Date: 26 April 2021
Reference: L2466

Bridge House, Oxford Road, Uxbridge UB8 1HS

The Hierarchy of Drainage

Status :		CONSTRUCTION	
Scales : As indicated @ A1		Date : Oct 19	
Drawn : KK	Engineer : VM	Checked : M	
Drawing No.		Revision:	
BRH-PRJ-XX-00-DR-C-07000		C

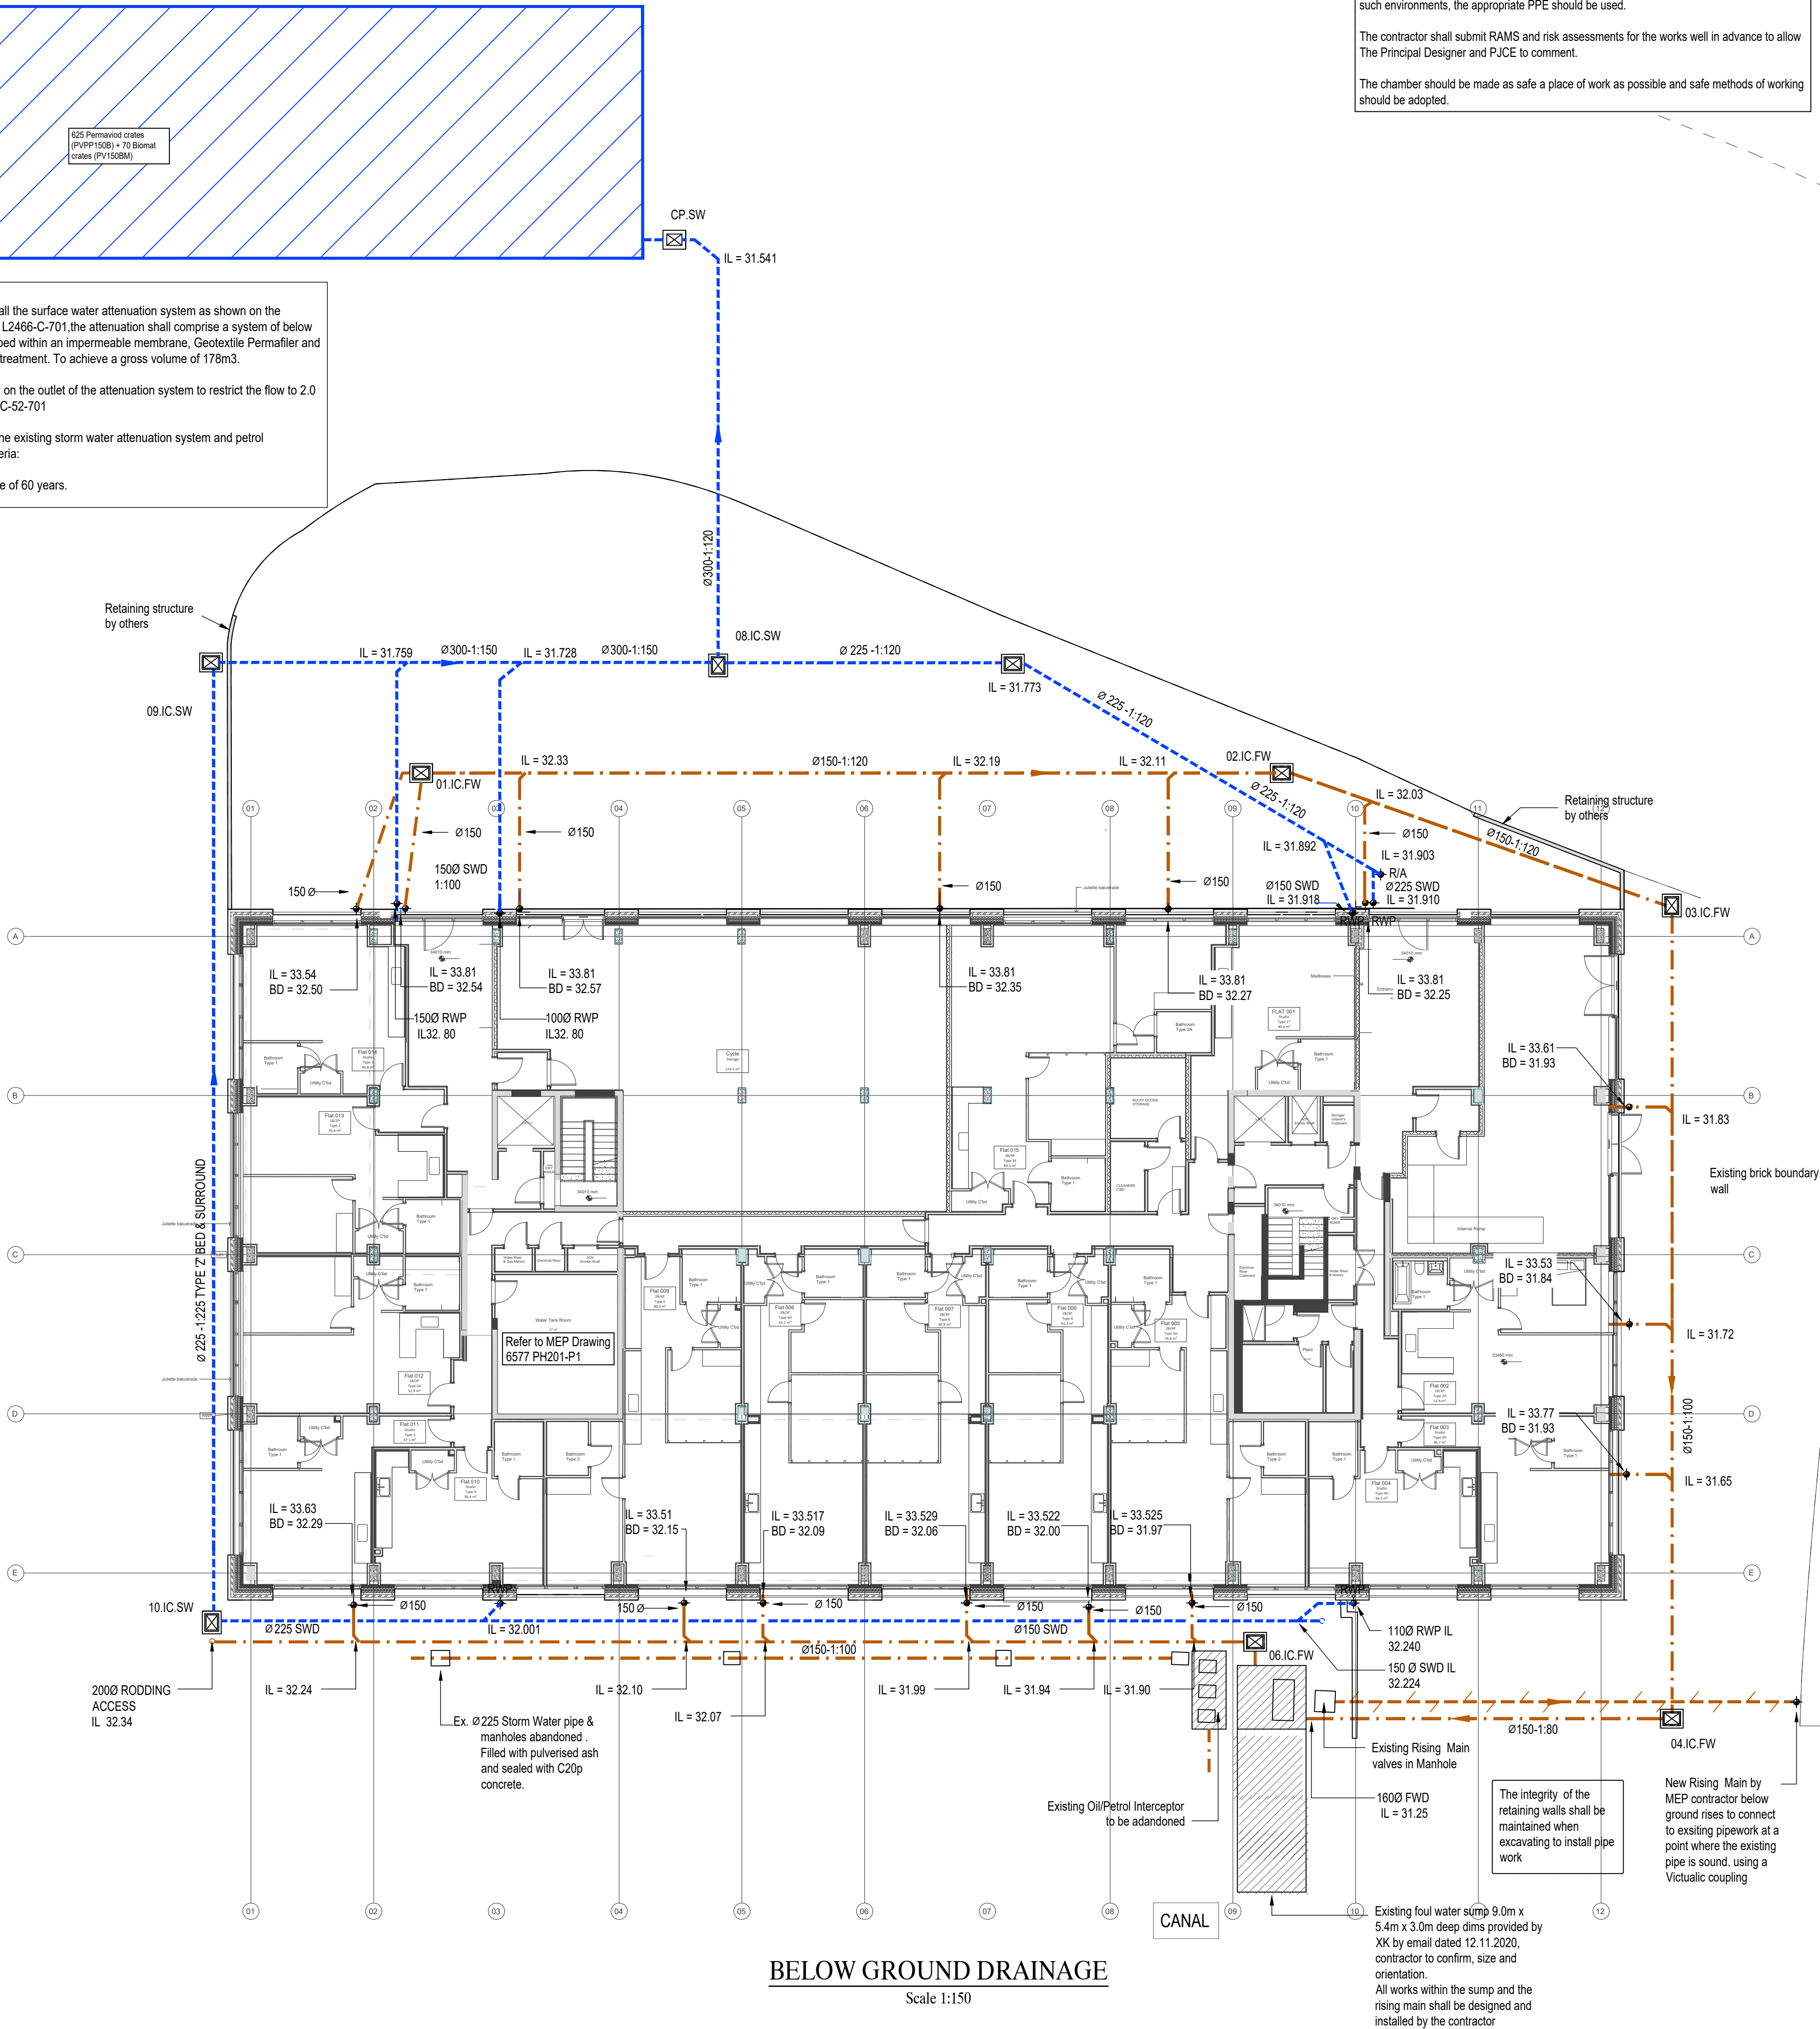
"The Council's Flood and Water Management Officer has reviewed the submitted details and stated that the proposed discharge rates are considered acceptable, however it is not clear that this is the most sustainable design, and that more sustainable options cannot be included. Are you able to provide additional information clarifying this point?"

The proposed surface water discharge is to the River Colne via a 178m³ attenuation with a permavoid biomat. This is detailed on drawing BRH-PRJ-XX-00-DR-C-07000, extract below.

Ground infiltration tests for deep borehole surface water discharge have been undertaken on the site and has shown the scheme to be unviable.

The site is straddled by the River Colne, in the north and the Canal in the south. The most appropriate discharge for the surface water is to the adjacent River Colne.

The discharge to other surface water sewers was considered but given the River Colne is immediately adjacent the site, this alternative was considered as lower on the National Planning Practice Guidance details the hierarchy of drainage and rejected.
